RESPONSE TO SUBMISSION CLAUSE

In response to the issues and concerns raised by the DP&I, other government agencies, third party commercial stakeholders and residents. A number of changes have been made to the proposed development in response to these concerns and these changes are listed in the Table 1 below and shown on the revised Architectural Plans prepared by COC Architecture (Appendix B)

The University of Sydney - Engineering & Technology Precinct Stage 1

Project
THE UNIVERSITY OF SYDNEY ETP STAGE 1
Electrical Engineering Building
University in Darlingtown, NSW 2008
Drawing Title
FLOOR PLAN - LEVEL 02

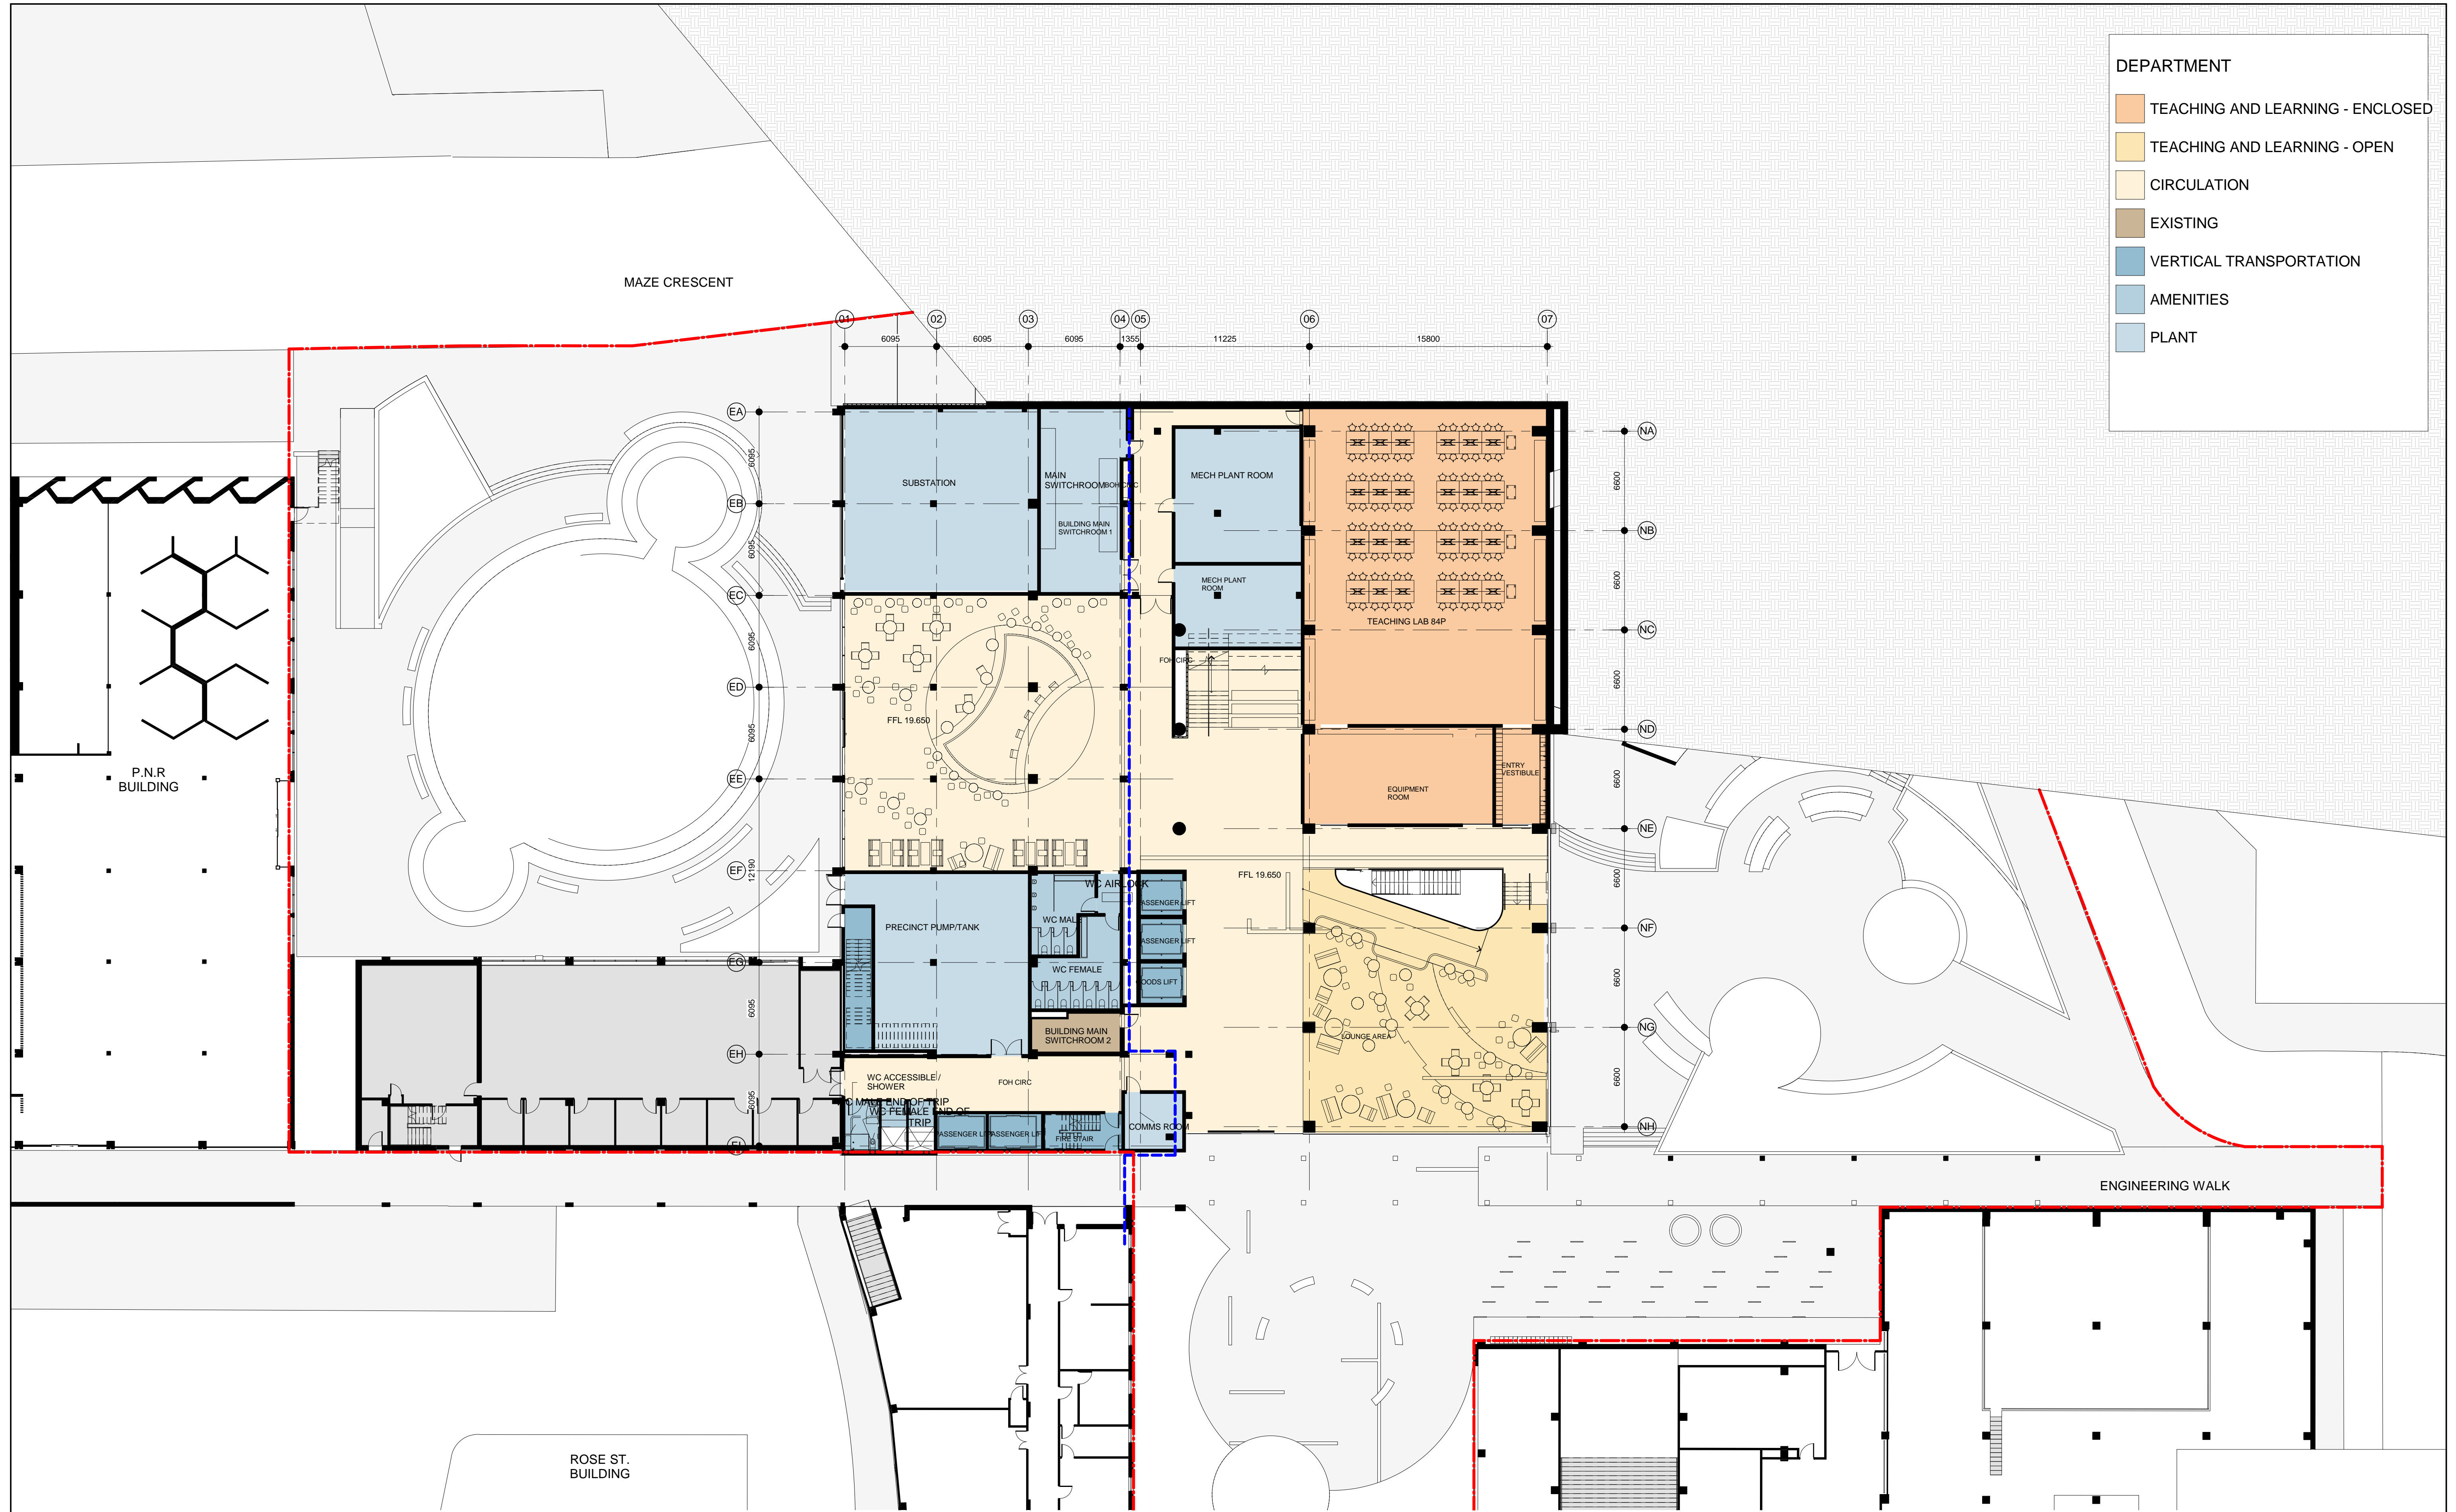
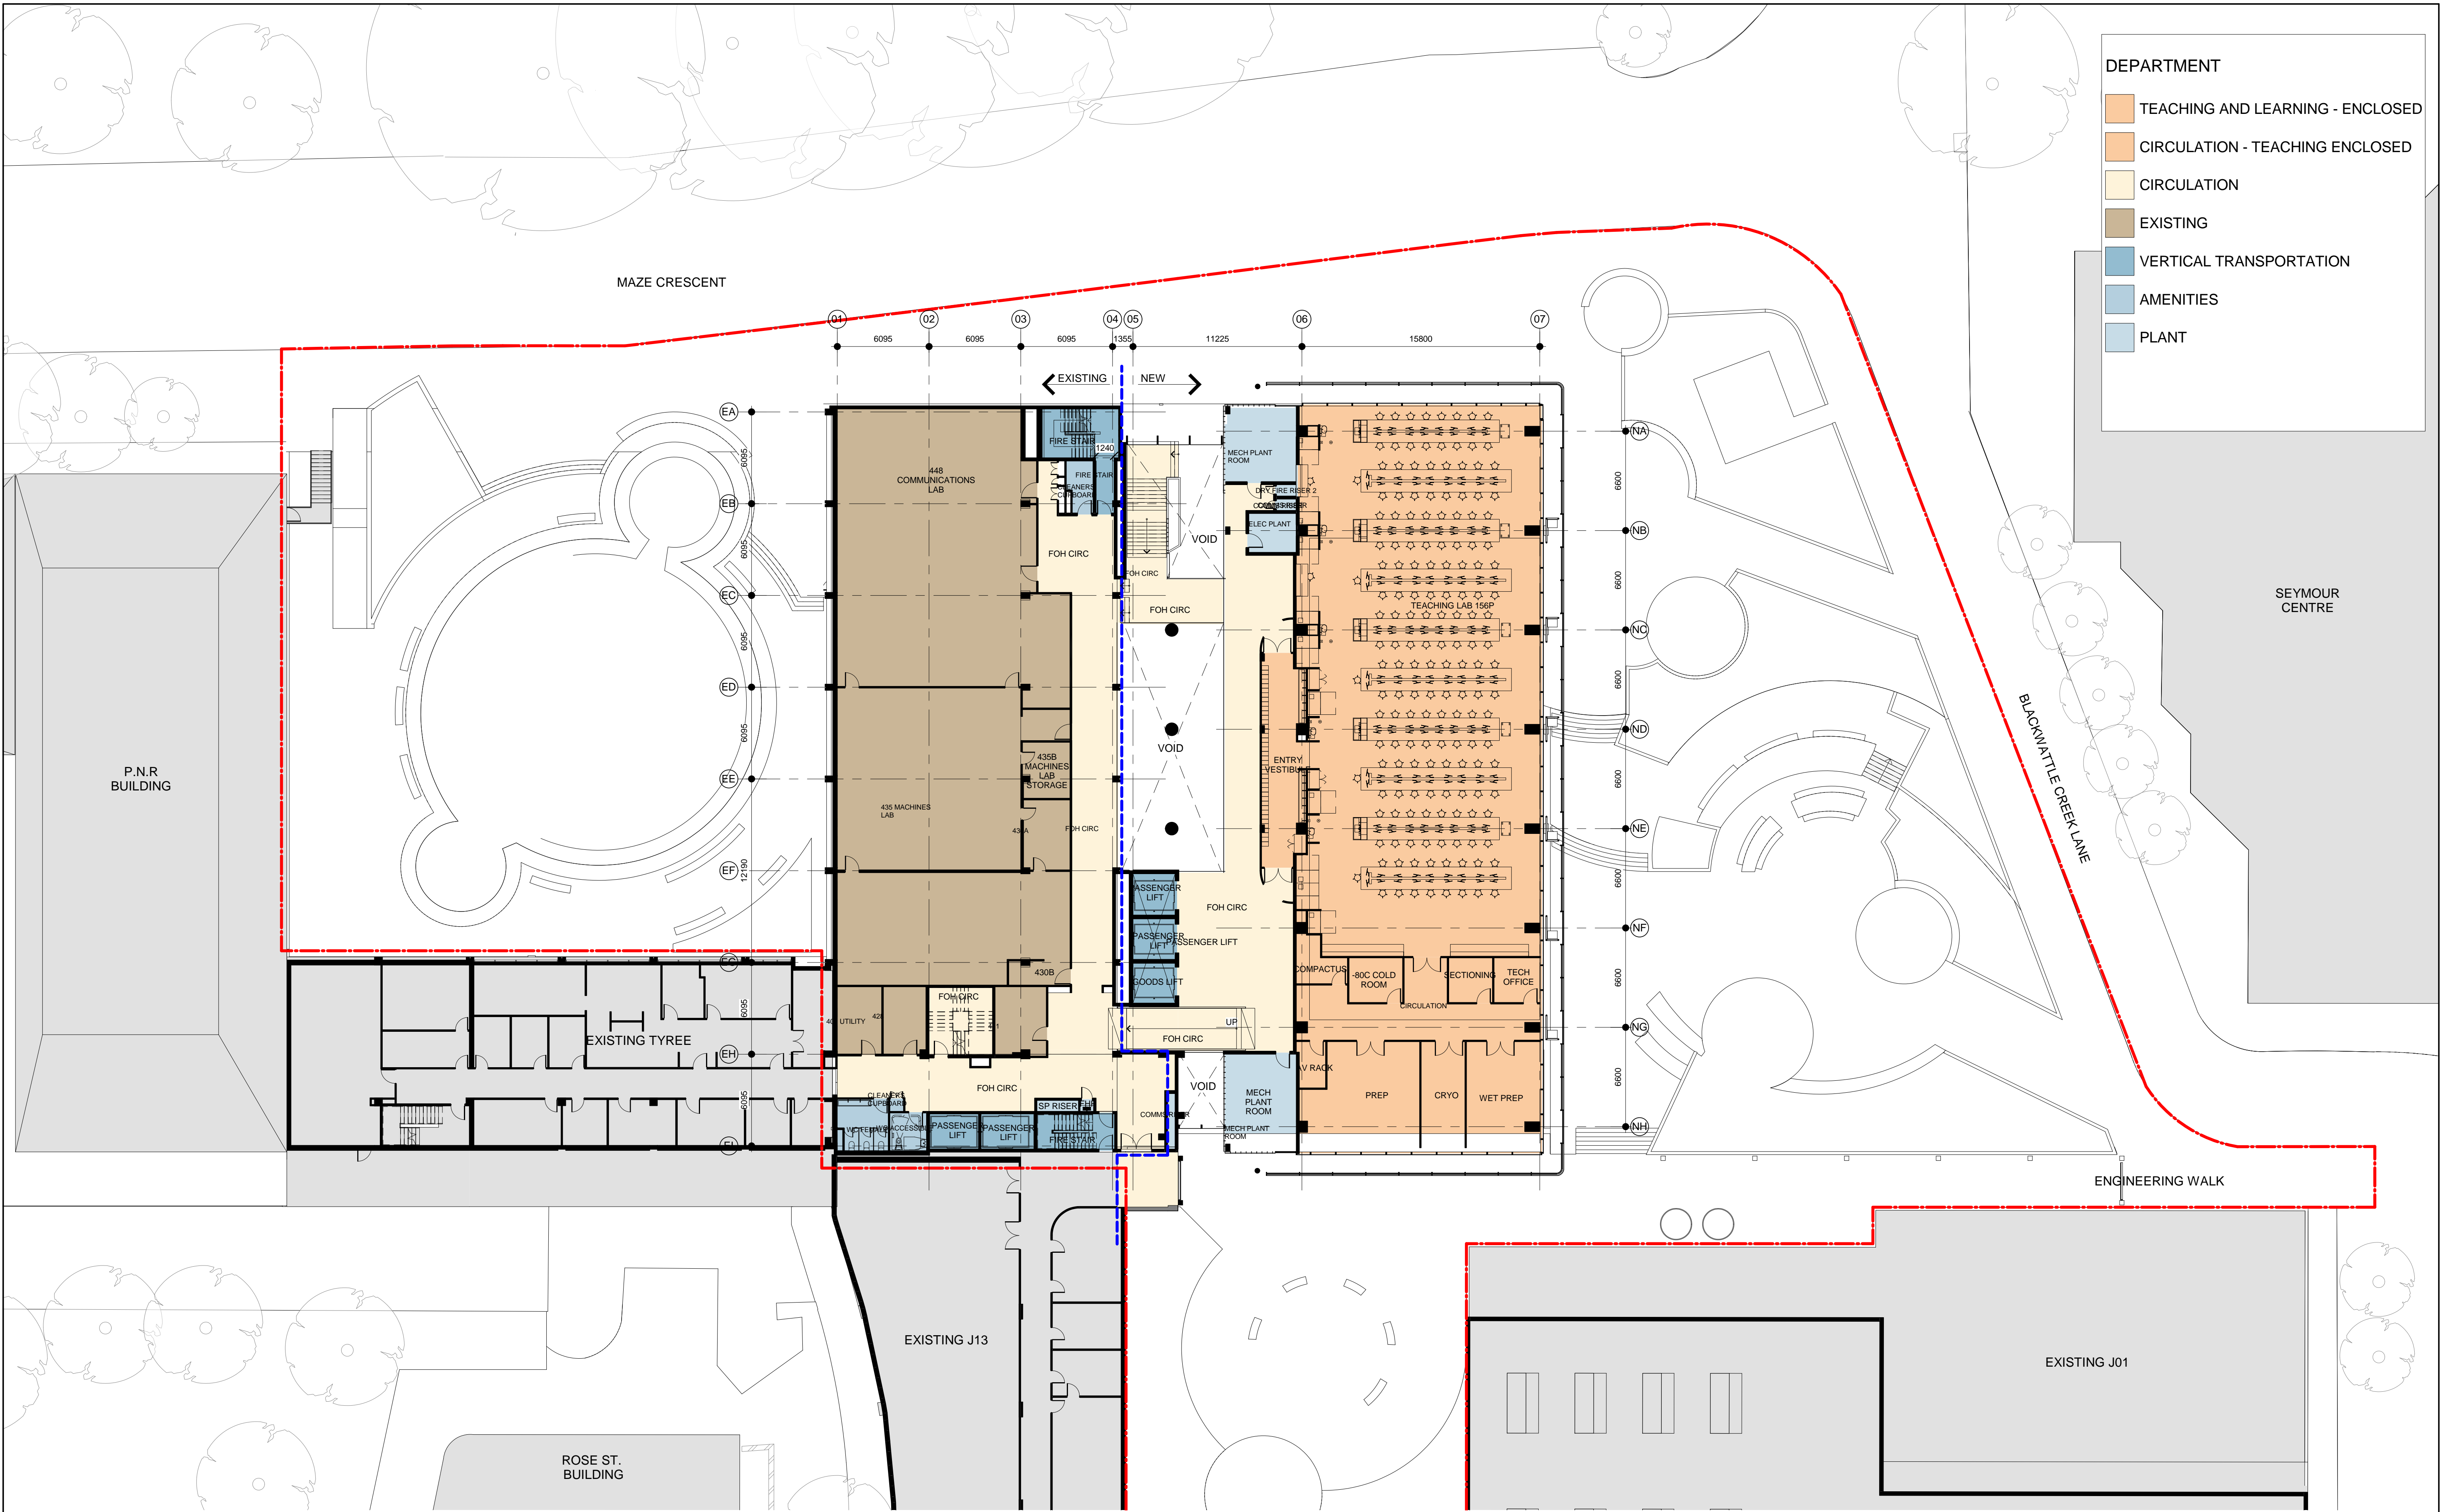
A-DA-2102	FLOOR PLAN - LEVEL 02	D	<ul style="list-style-type: none">• End of trip facilities (2 showers) added• Updated bike rack count• Deletion of engineering walk awning• Addition of risers along grid 06	<ul style="list-style-type: none">• 3.14 - End of trip facilities• 1.06 - End of trip facilities
A-DA-2103	FLOOR PLAN - LEVEL 03	D	<ul style="list-style-type: none">• Updated stair at western end• Deletion of the portals and engineering walk awning• Landscaping updated• Risers added along grid 06	
A-DA-2104	FLOOR PLAN - LEVEL 04	D	<ul style="list-style-type: none">• "Interconnecting accommodation stair" annotation added• "& School hub" added to the name of room name 448• Department filled region extent amended to suit floor plate• Landscaping updated	
A-DA-2105	FLOOR PLAN - LEVEL 05	D	<ul style="list-style-type: none">• Department filled region extent amended to suit floor plate• Riser along grid 06 added• Landscaping updated
